Our Case Number: ABP-318540-23

Re: 10 year planning permission for the proposed Open Cycle Gas Turbine (OCGT) power plant fuelled by Hydrotreated Vegetable Oil (HVO) and associated site works at Tarbert Island, Tarbert, Co. Kerry. (www.ssetarbertnextgen.com)

Date: 1st February, 2024

Re: Strategic Infrastructure Development - ABP- 316229 – Proposed 350MW Low Carbon Open Cycle Gas Turbine (OCGT) fuelled by hydrotreated vegetable oil, administration building and workshop, and ancillary plant and infrastructure in Tarbert Power Station, Tarbert, Co. Kerry

C-C | SOUTH EAST ELEVATION
1:150

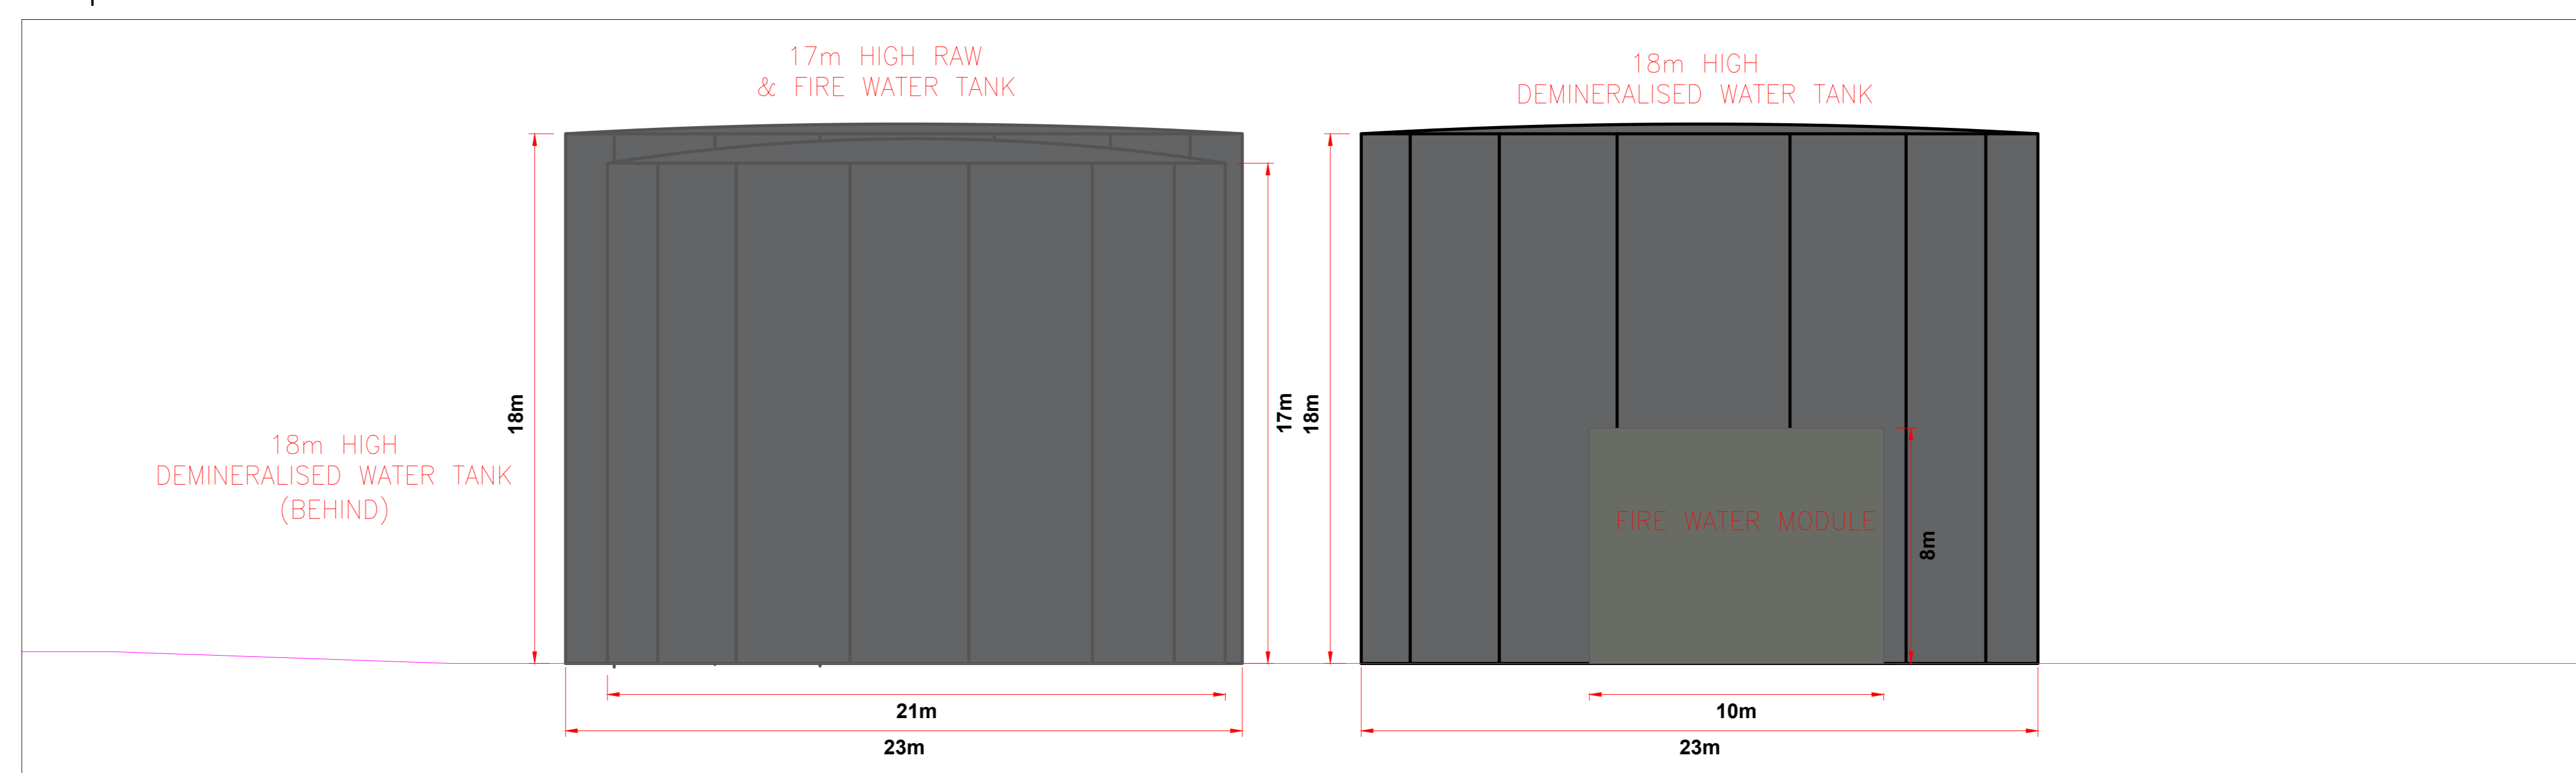
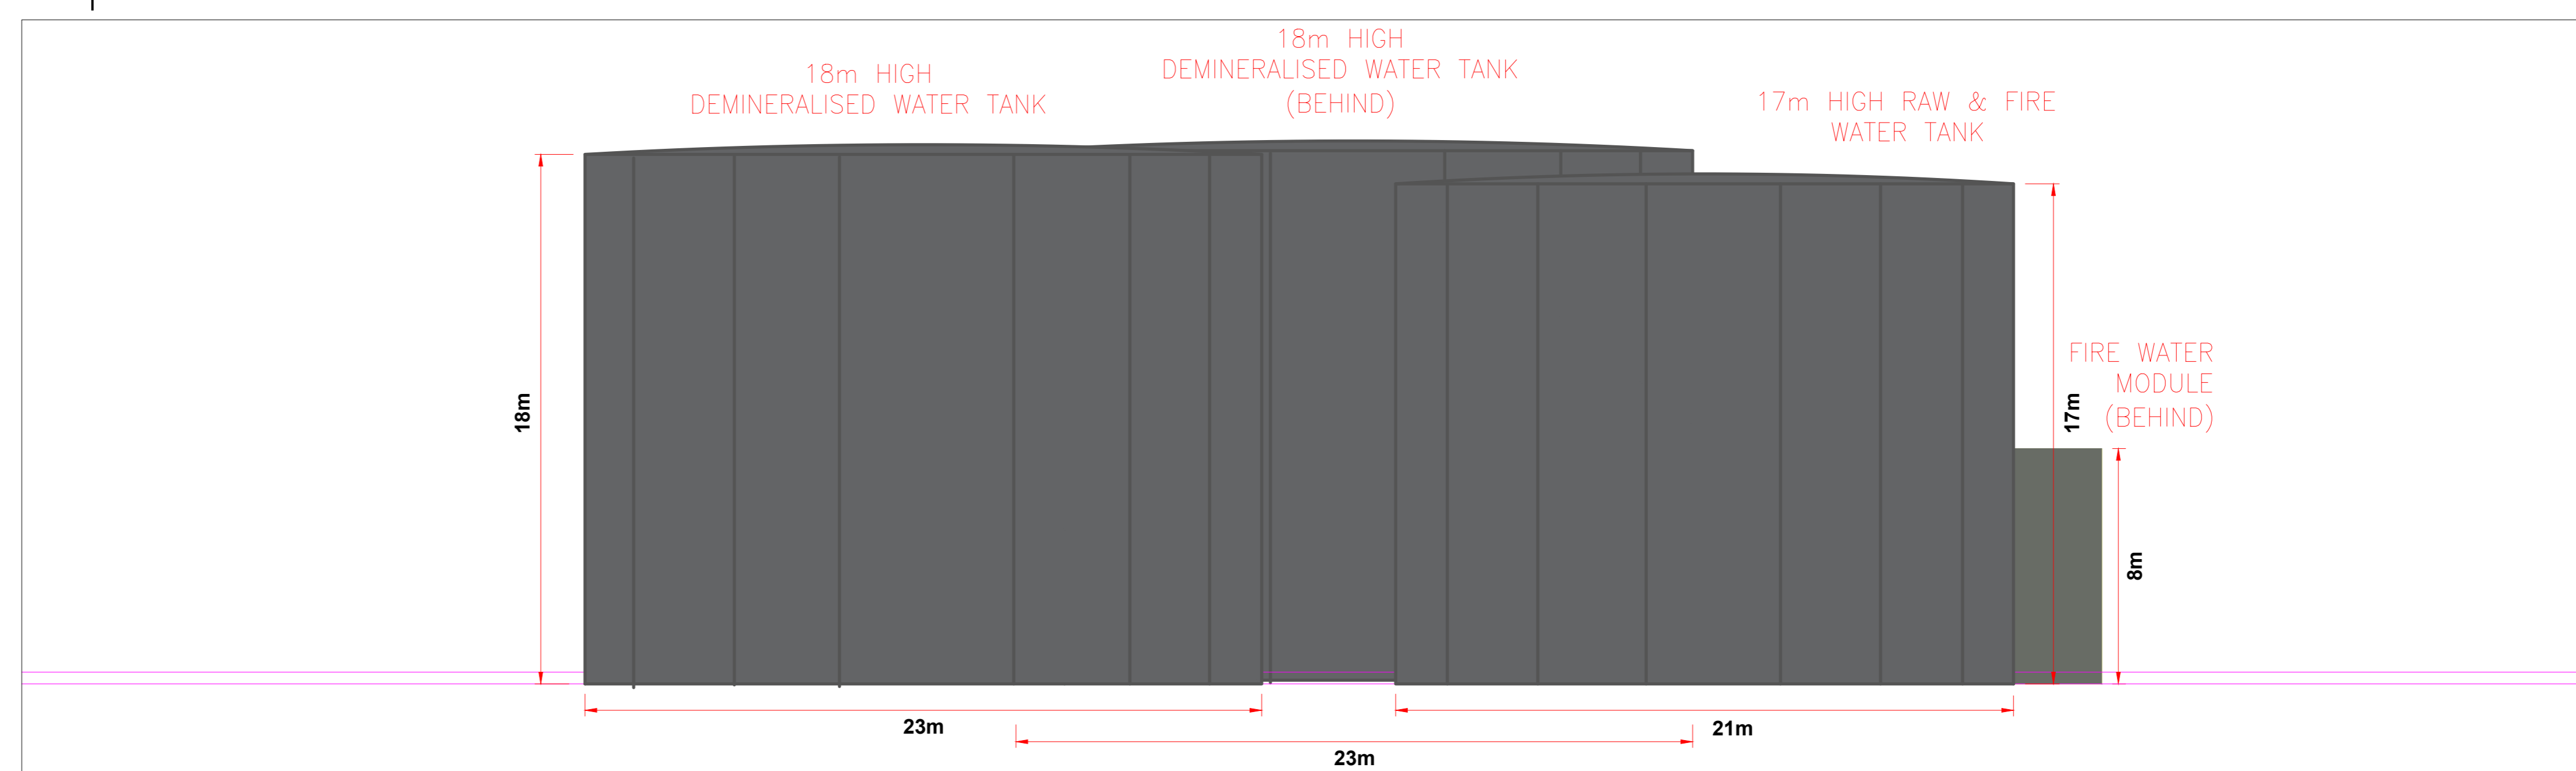
It is noted in Section 5.2.5 'Water Supply' in the Environmental Appraisal Report that it is expected when in operation, the proposed development will require up to c.150m³ per hour of demineralised water. Whilst UÉ notes the overall proposed reduction in water usages, the supply remains significant and volumes of this nature, in addition to the proposed firewater/water storage tank of approximately 5,900m³ will need to be considered as part of UÉ's feasibility assessment.

UÉ have subsequently been in contact with the Applicant's agent and have been provided with some further detail/ figures in terms of the proposed volumes of water usage. UÉ have some concerns with the figures being proposed, particularly what the peak flows might be and the potential impacts on the reservoir storage as well as the impacts on existing watermains and networks.

- Calculations including peak and seasonal water demand profiles
- To include:
 - Details for the proposed 2 no. Demineralised water storage tanks
 - Details for raw water and fire water storage tank
- Detailed and current demand profiles to inform supply and hydraulic modelling

- The applicant shall engage with Uisce Éireann by submitting a pre-Connection Enquiry (PCE) to assess feasibility of connection to the public water / wastewater infrastructure.
- The outcome of the PCE is to be submitted as a response to Further Information Request.
